**Consultation Response from KC,
Conservation & Design**

2026/91339 Slaithwaite Railway Viaduct, Nabbs Lane, Slaithwaite, Huddersfield

**Listed Building Consent for installation of five overhead electric line equipment portals on piers 3, 7 and 11 with supporting wall brackets; tubular handrail to replace existing on span over Bank Gate; new downpipes on same piers connected to existing outflow pipes.
Reinforcement of the north parapet with precast concrete L units, and rebuilding north side of eastern terminating span over Bank Gate, including replacement of bridge deck, parapet, and reconstruction of flanking pilasters (within a Conservation Area)**

Date Responded: 13/8/26

Drawing Title: **Listed Building Consent Drawing - MVL3/61 Slaithwaite Viaduct - Proposed Elevation and Section**

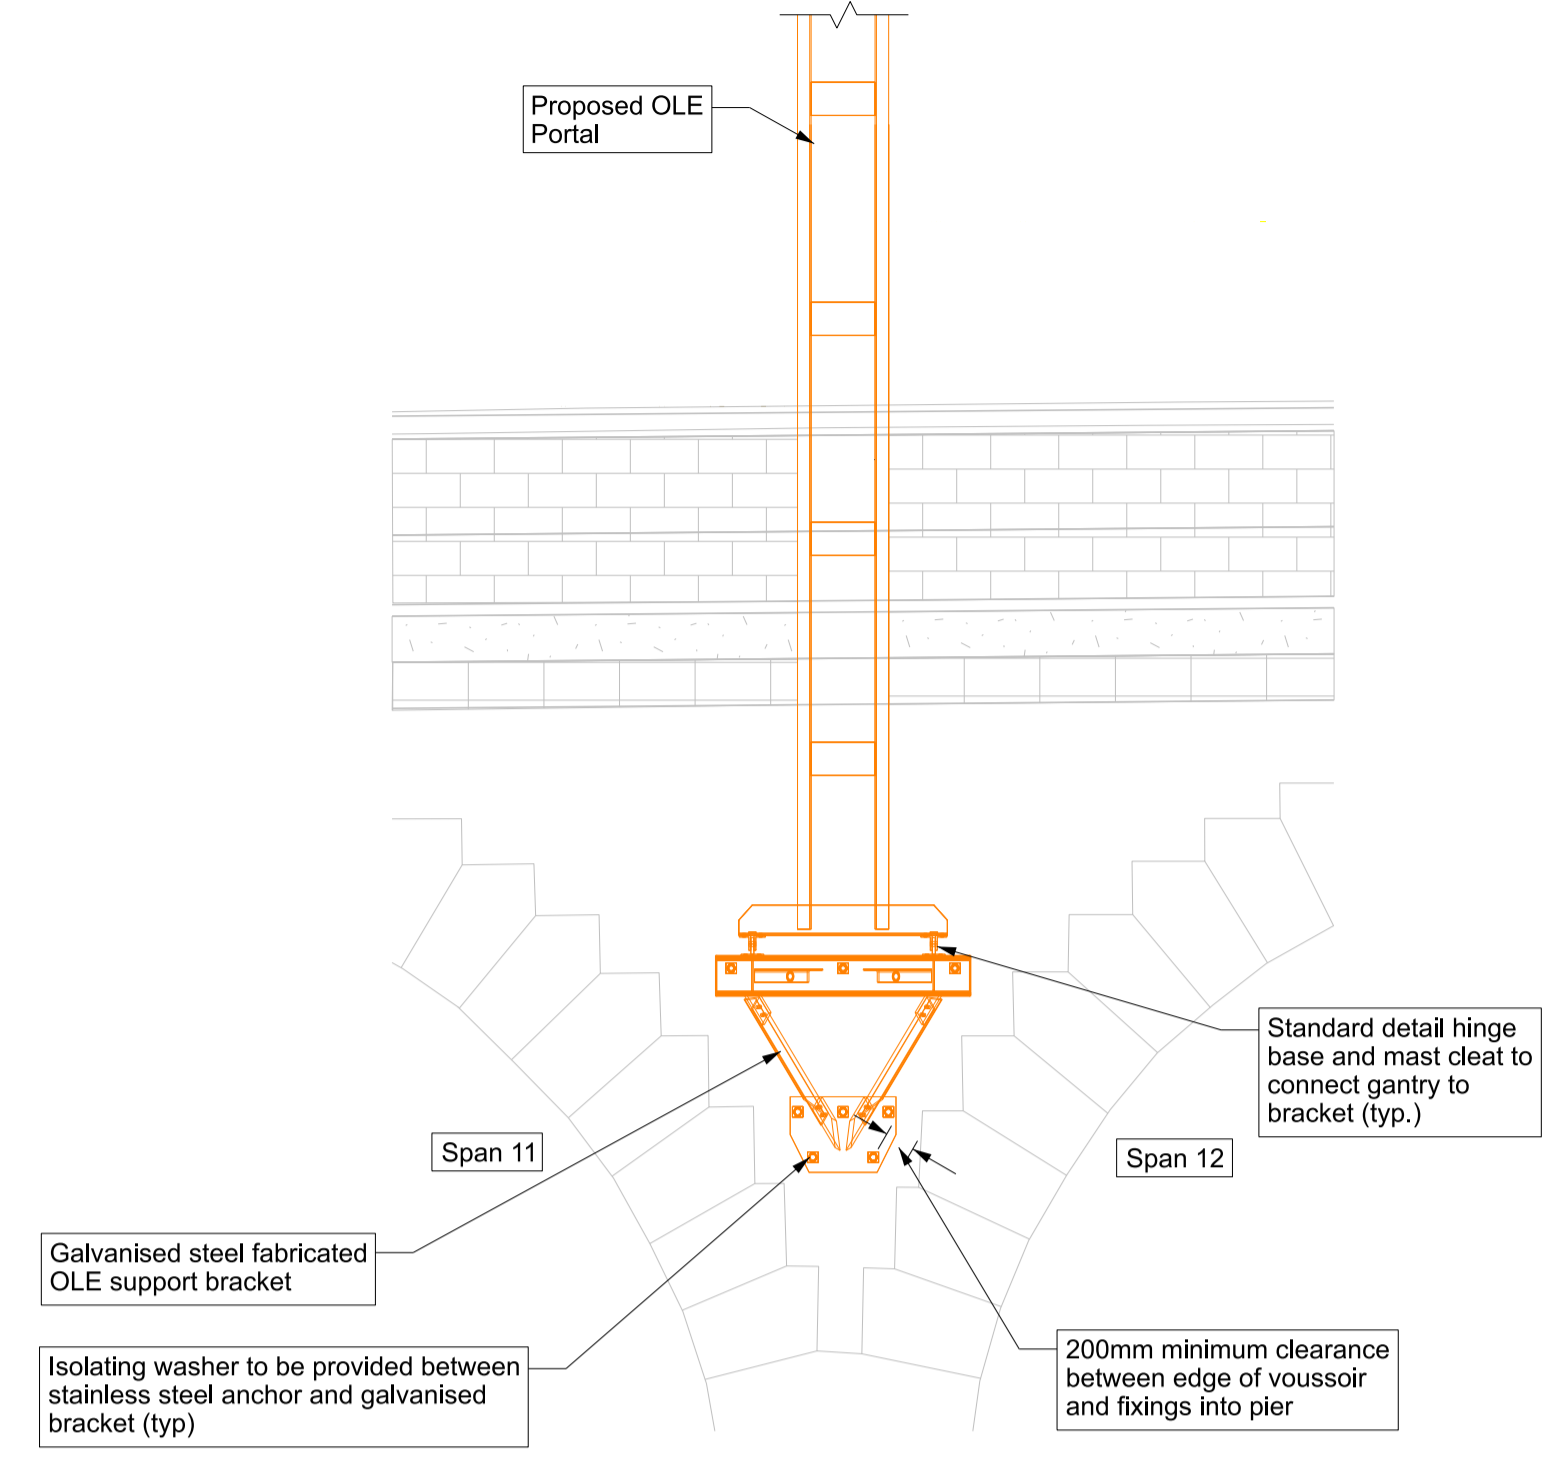
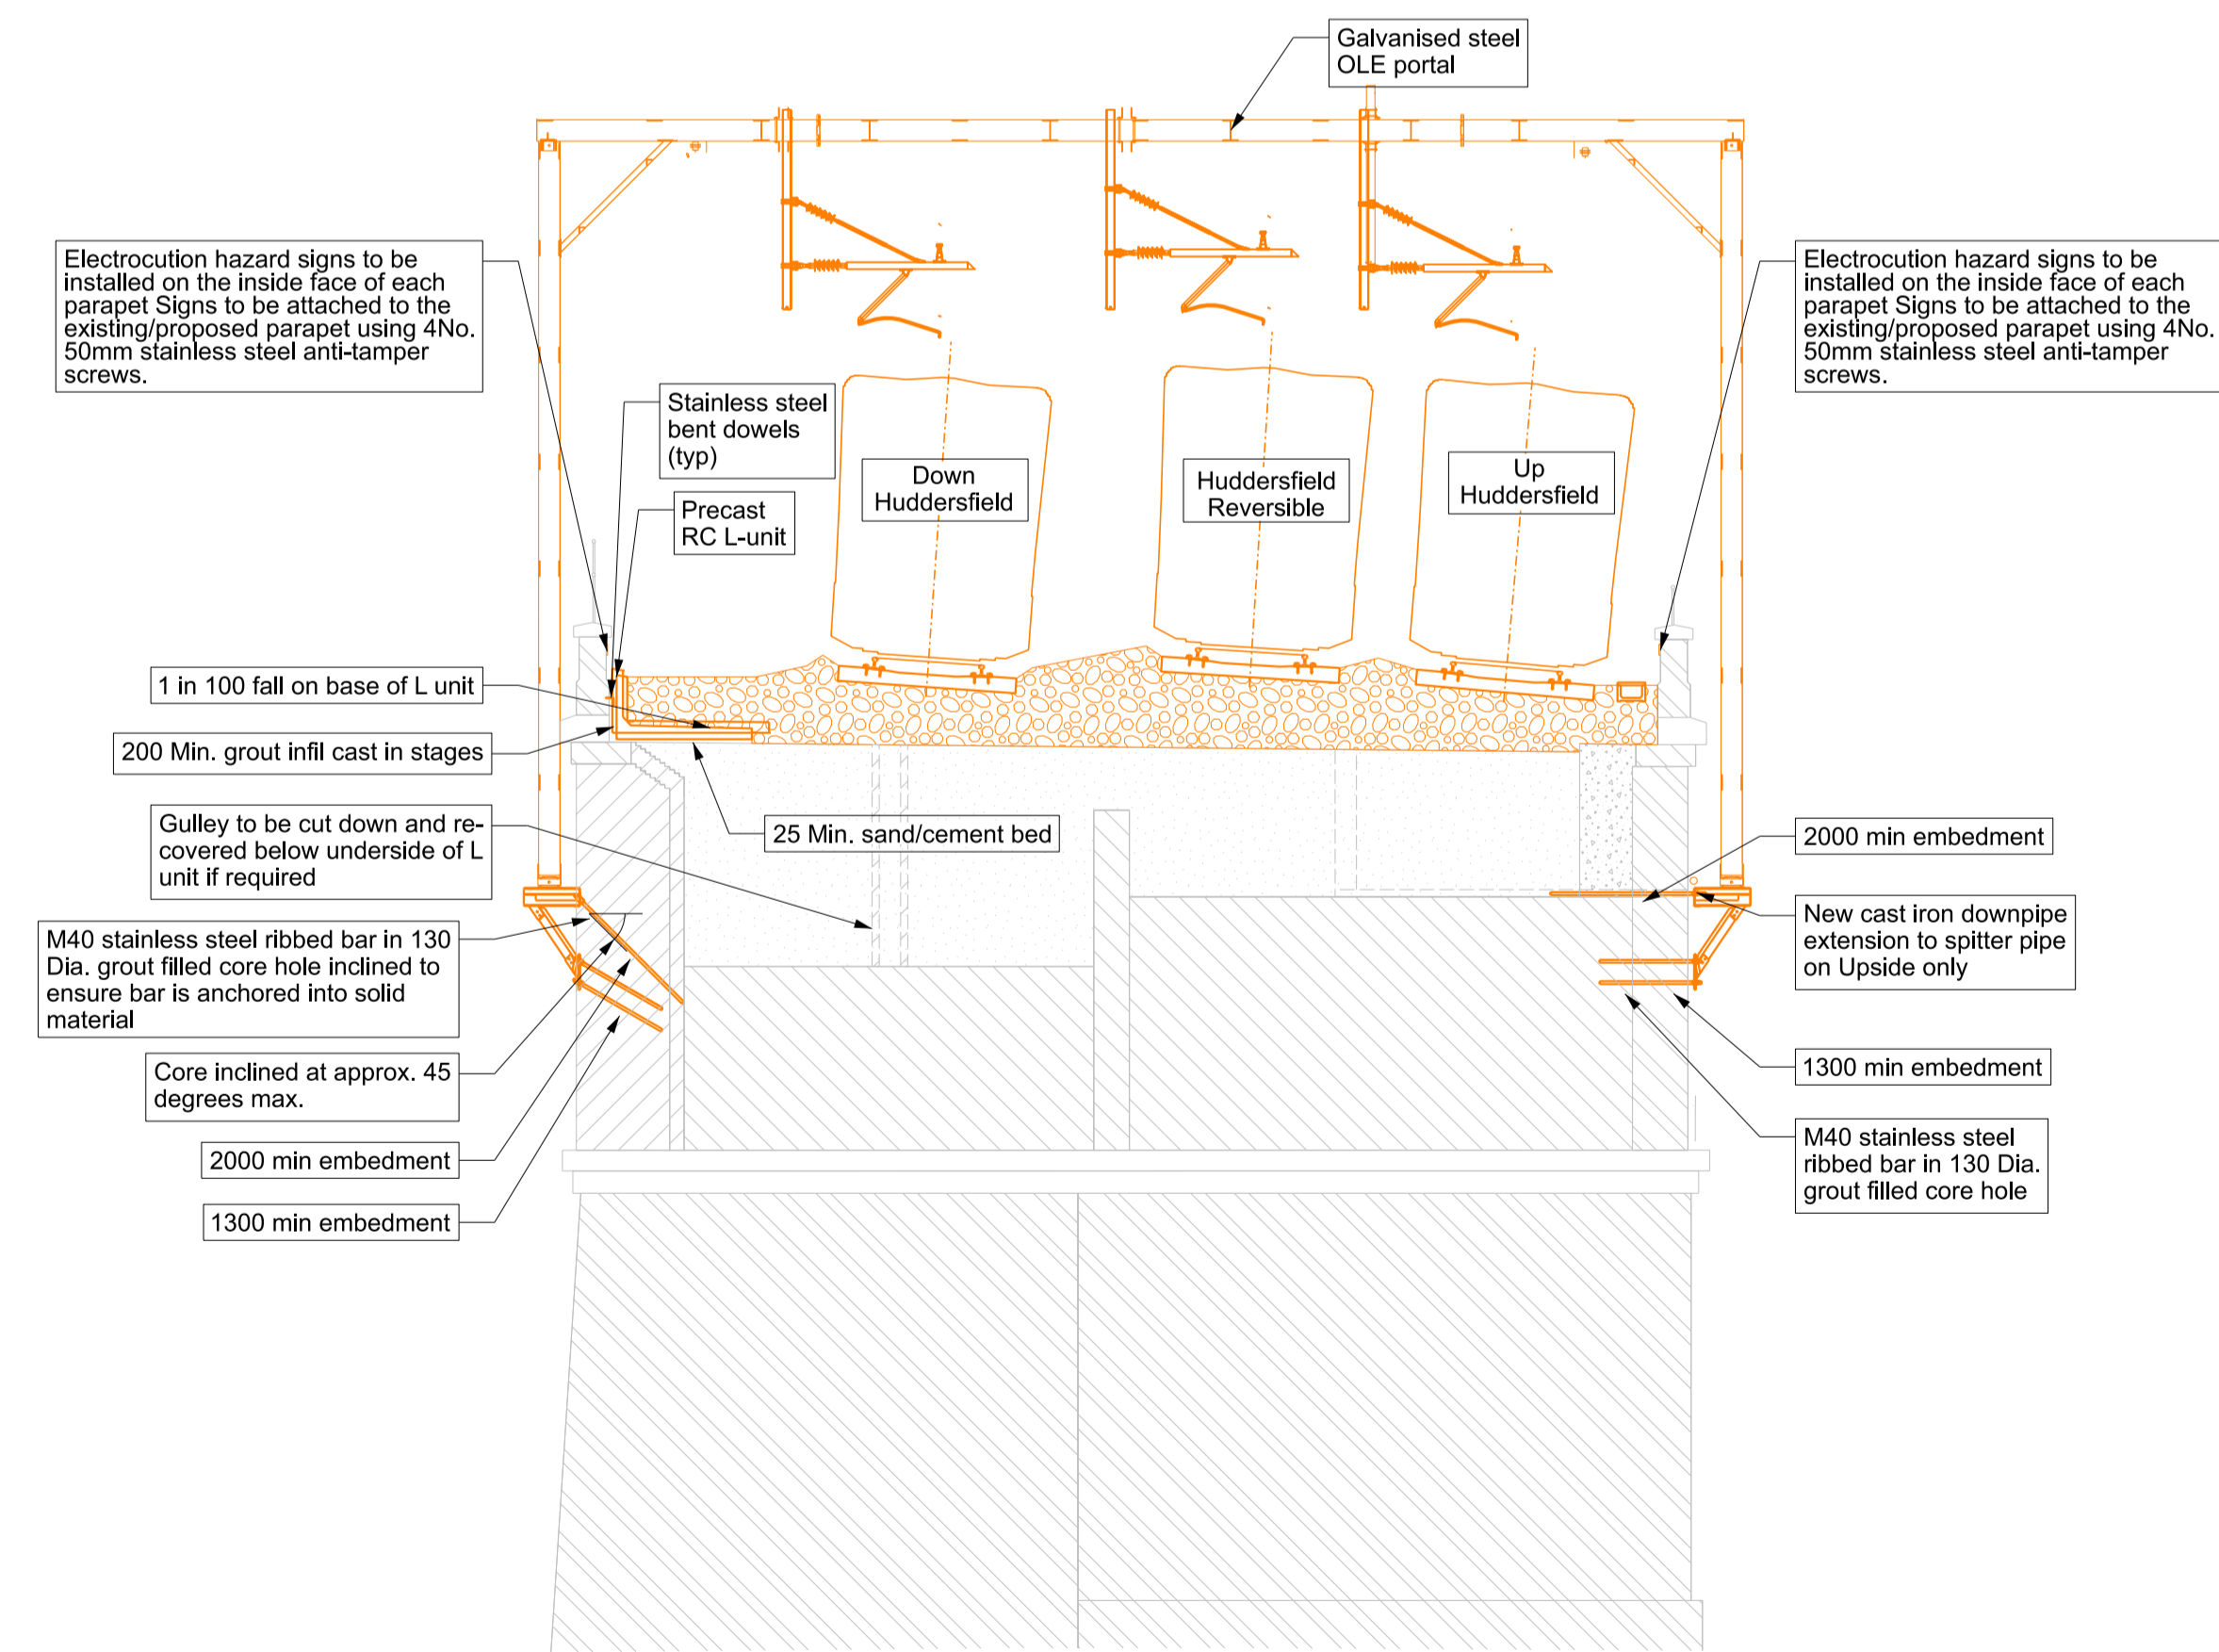
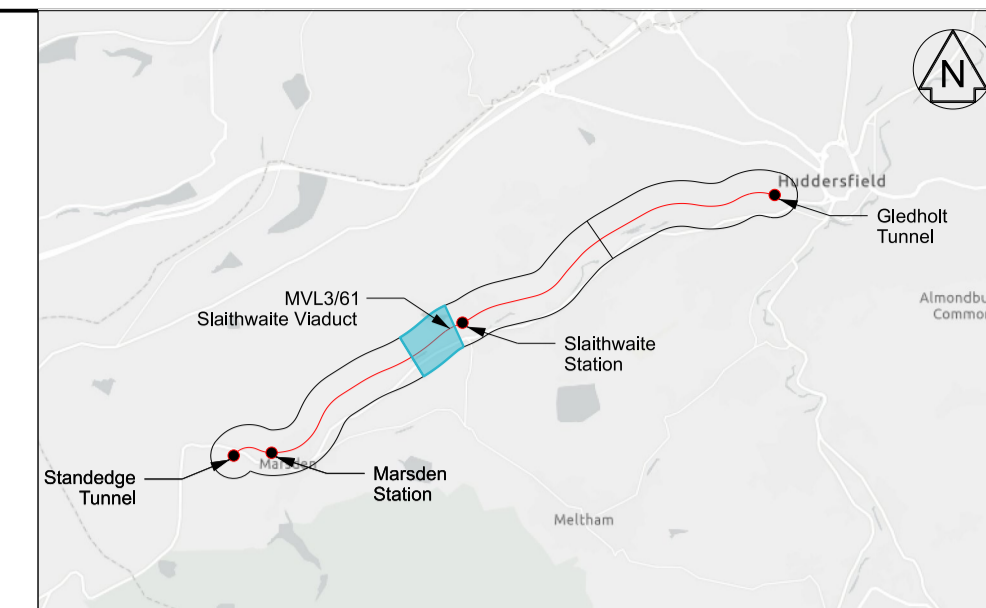
The design and detailing of the mounting brackets enables the OLE portals to be erected proud of the parapet string course, rather than flush to the face. The bracket fixings are also detailed to be positioned within the spandrels at a minimum 200mm clearance from the edges of the voussoirs forming the viaduct arches. This string course and arch voussoirs will therefore not be damaged by the installation of the OLE portals.

1. Details, finishes and methods of fixing to match details of OLE proposed for WC3.
2. Tubular handrails colour finish to match existing.
3. Cast iron downpipes to be finished in either black or stone colour.
4. New natural stone coursing to match existing as closely as possible in terms of type of stone,
